Phone: 0300 123 6780
Email: lhscustomerservice@lancashire.gov.uk
Your ref: NC2/3/2015/0178
Our ref: LHS/CS/ NC2/3/2015/0178
Date: 28th April 2015

Proposal:	Replacement of existing building used for tyre changing and valeting
Location:	Car Wash and Tyre Change Waterloo Road Clitheroe BB7 1NS
Grid Ref:	374688 - 442121

Stewart Gailey
Highway Development Control

Proposed Redevelopment
 Unit Albion Court
 Waterloo Road, Clitheroe
 Scheme Layout and Elevations

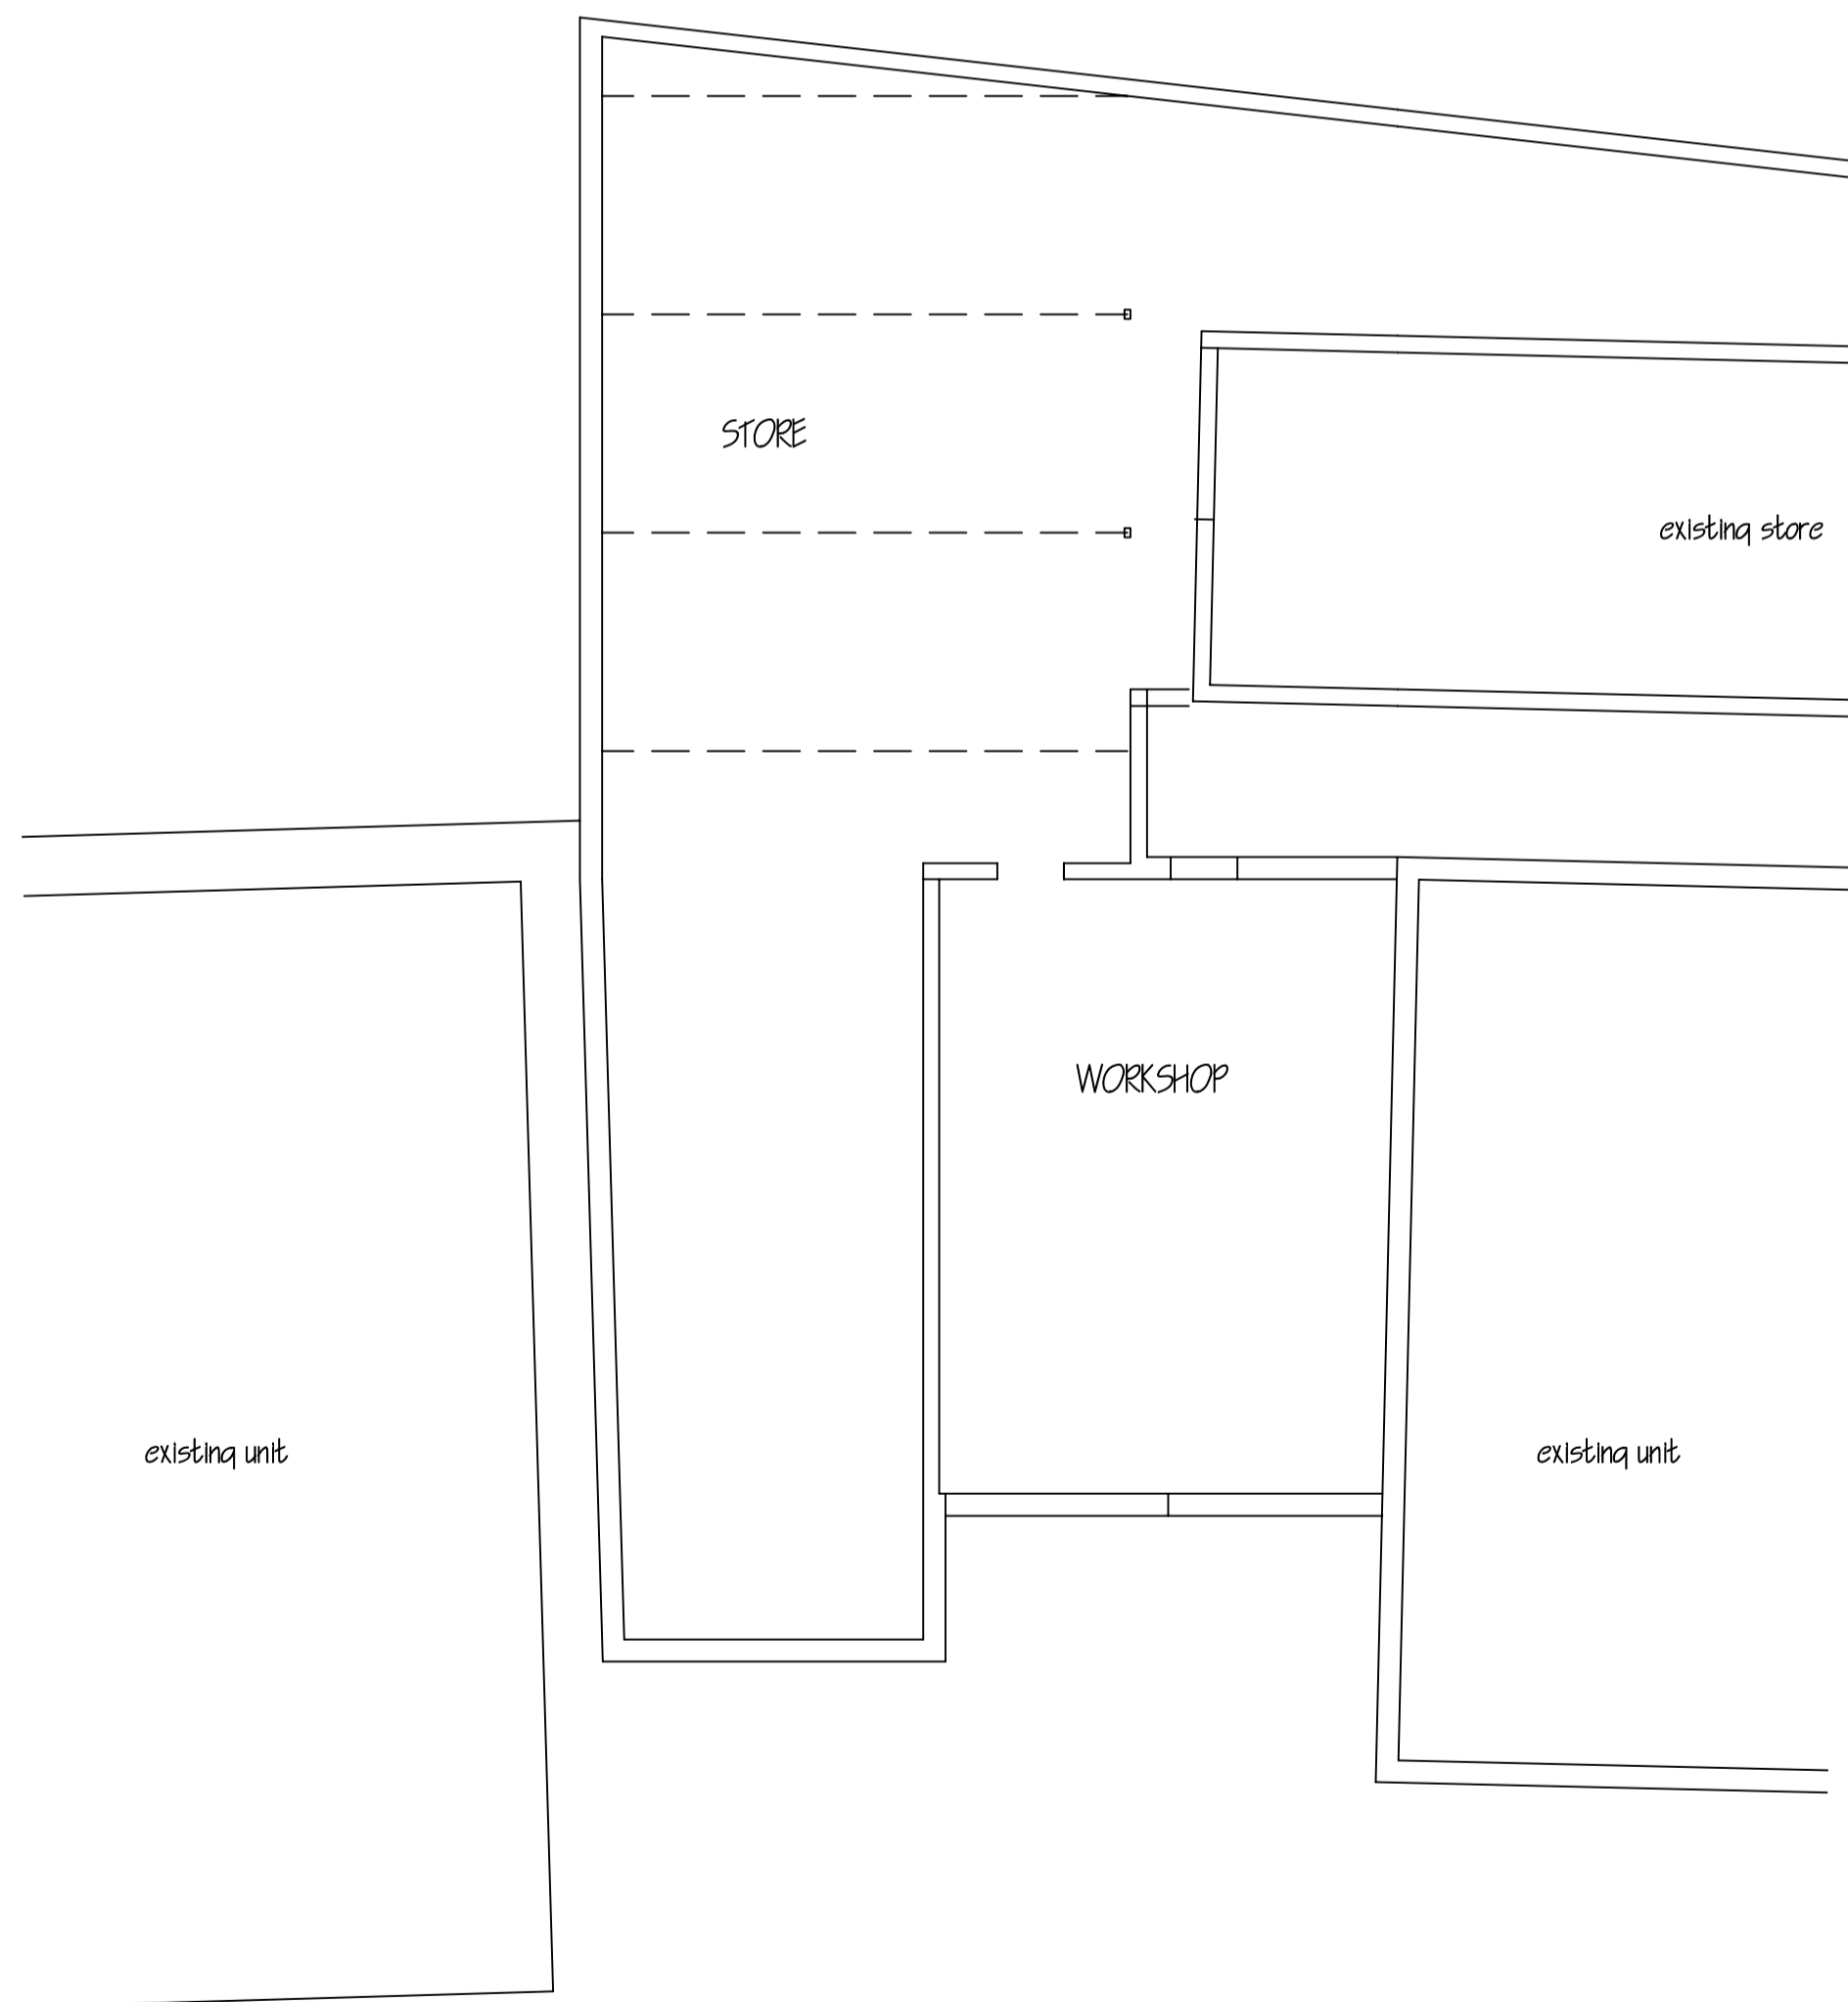
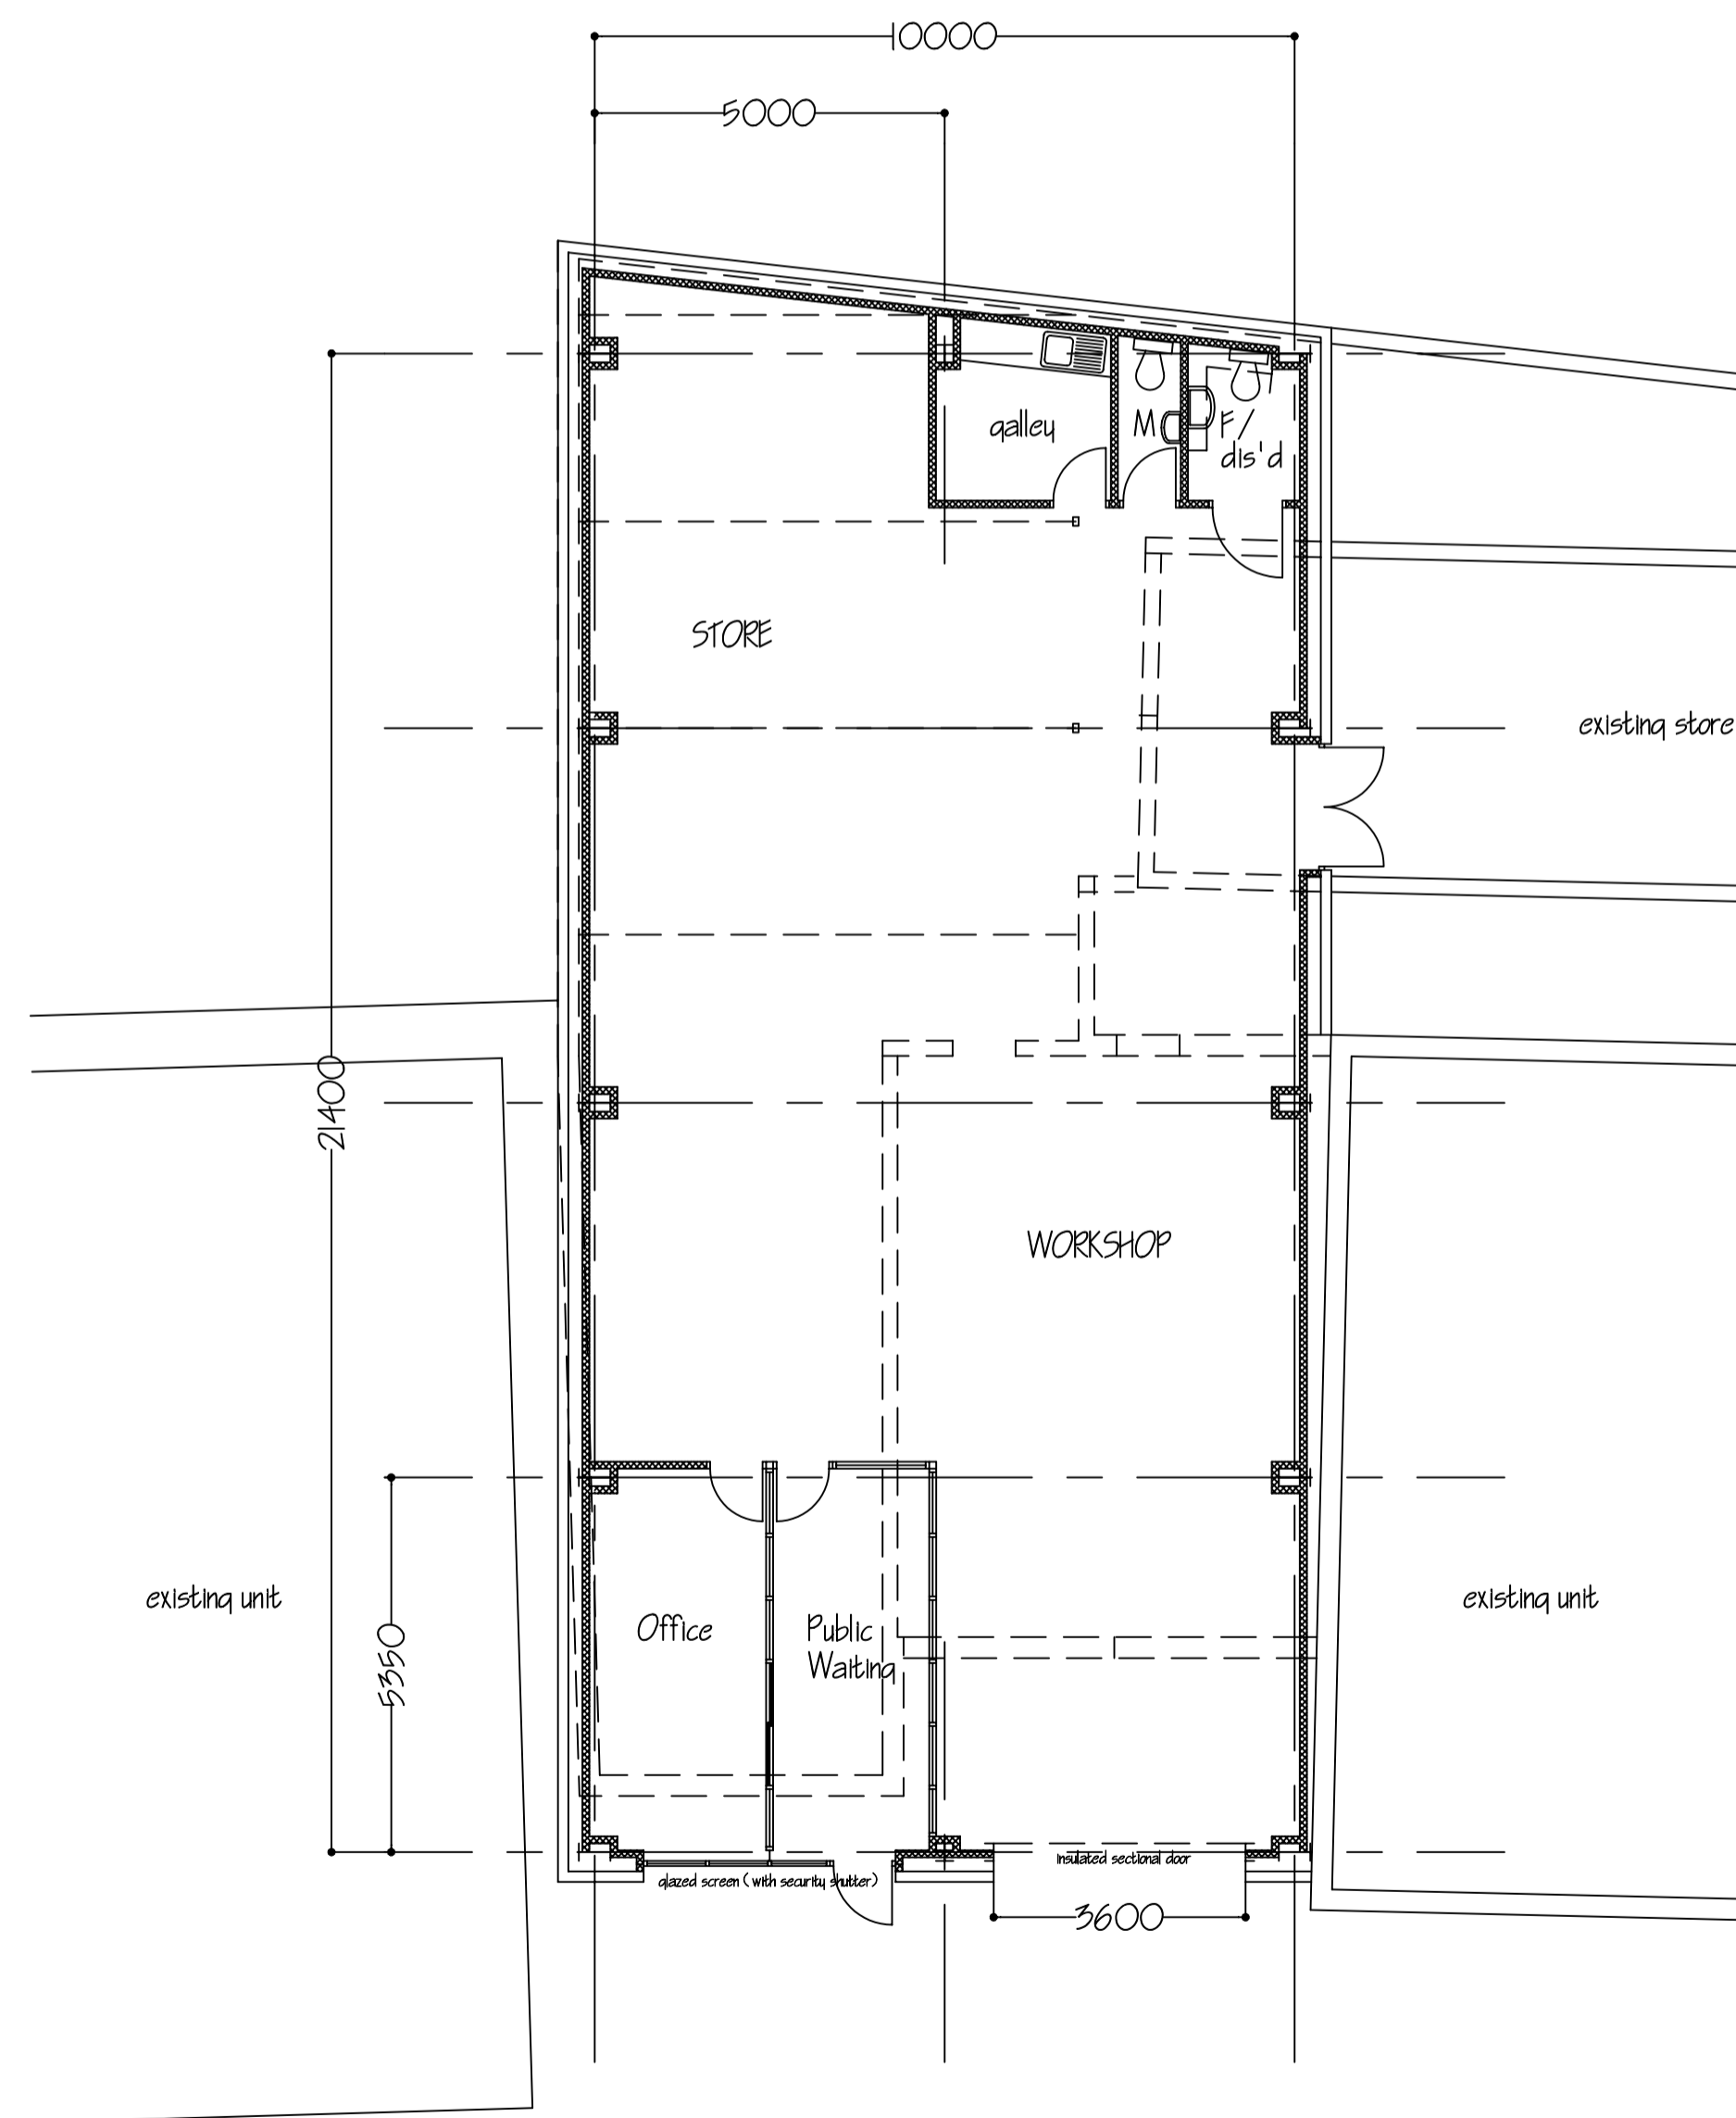
The Highway Development Control Section is of the opinion that the minor increase in floor area would not have a severe impact on the available off road car parking for this unit.

1. A car park and manoeuvring scheme to be approved by the Local Planning Authority and the car parking spaces and manoeuvring areas marked out in accordance with the approved plan, before the use of the premises hereby permitted becomes operative and permanently maintained thereafter. Reason: To allow for the effective use of the parking areas.
2. A Traffic Management Plan for the construction vehicles and staff accessing the site during the construction works, to be approved in writing by the planning department before any works begin on site. Reason: to protect existing road users.
